Rezoning Transportation Analysis

Petition Number: 2020-178

General Location Identifier: Tax ID 08108503

Date	Description
12-28-20	First Review (WB)
01-21-21	Second Review (WB)
02-24-21	Third Review (WB)

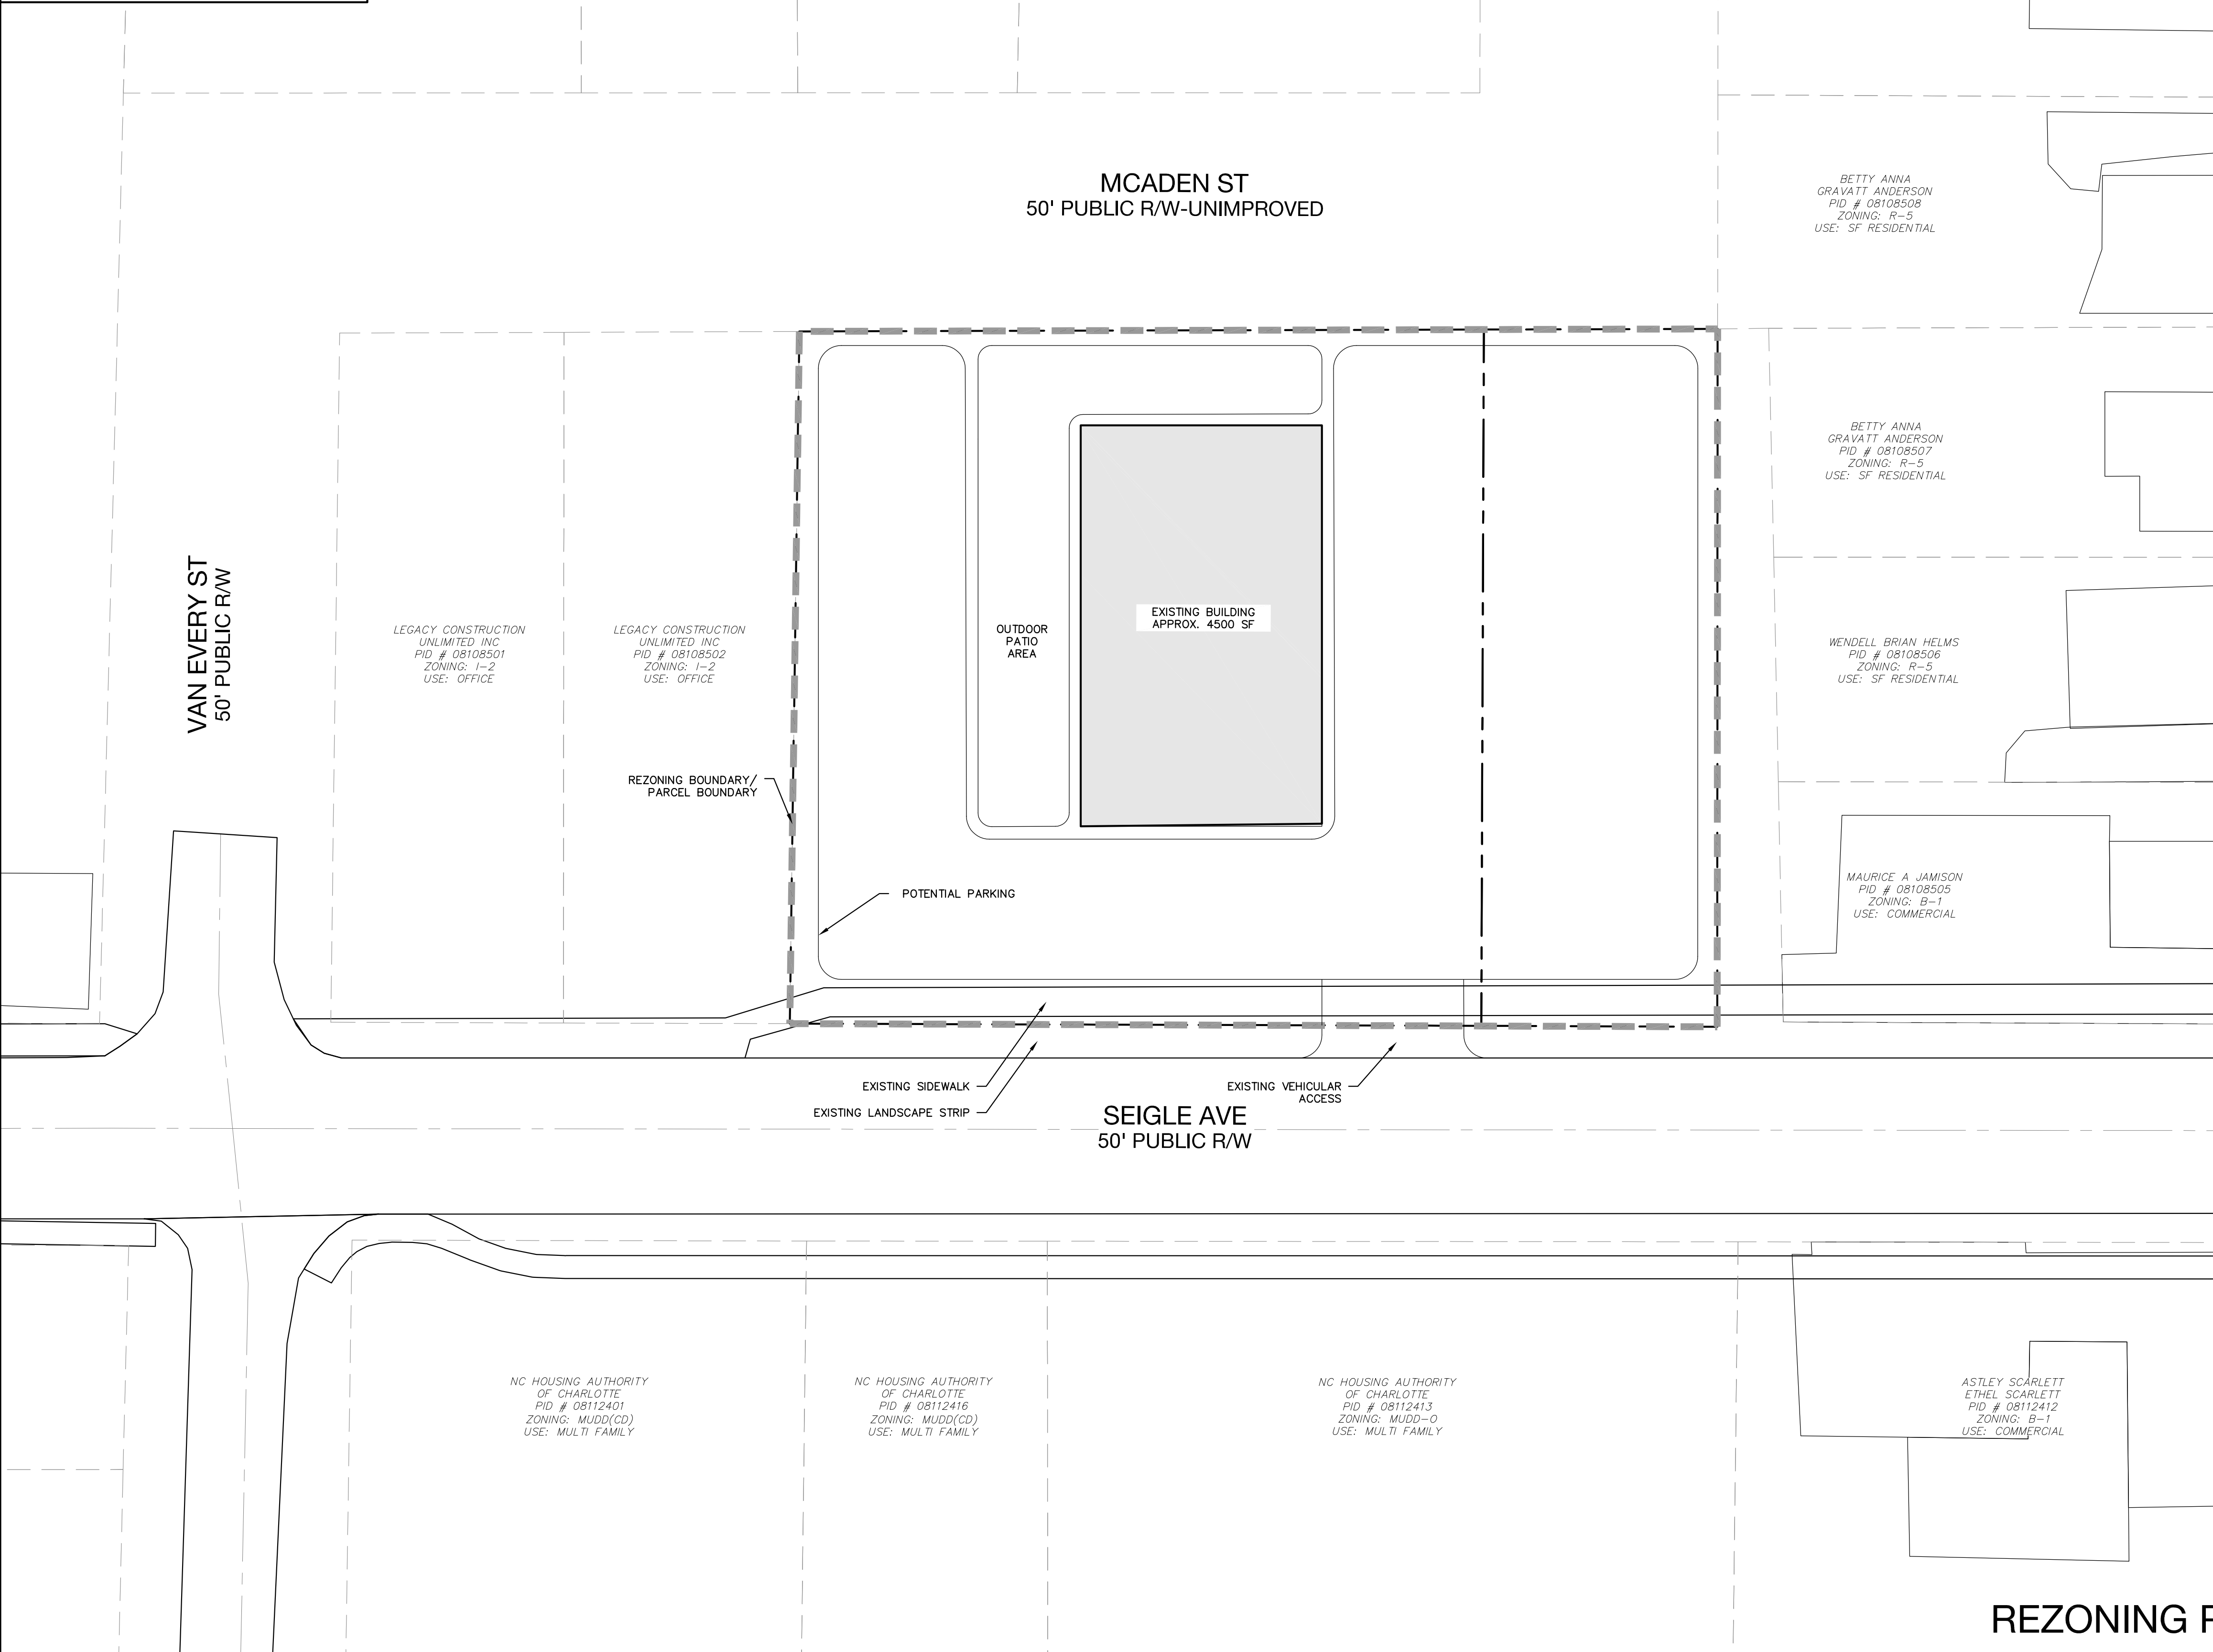
1. ~~**Curbline:** The proposed zoning district has a setback measured from back of the existing or proposed future curbline.~~

a. ~~**Seigle Avenue:** The future location of curb and gutter is in its existing location.~~

~~Label and dimension the curb and gutter from the centerline on the site plan.~~

3. ~~Revise site plan and conditional note(s) to commit to dedicating 30-foot right-of-way from the Seigle Avenue centerline. Label and dimension the right-of-way from the road centerline.~~
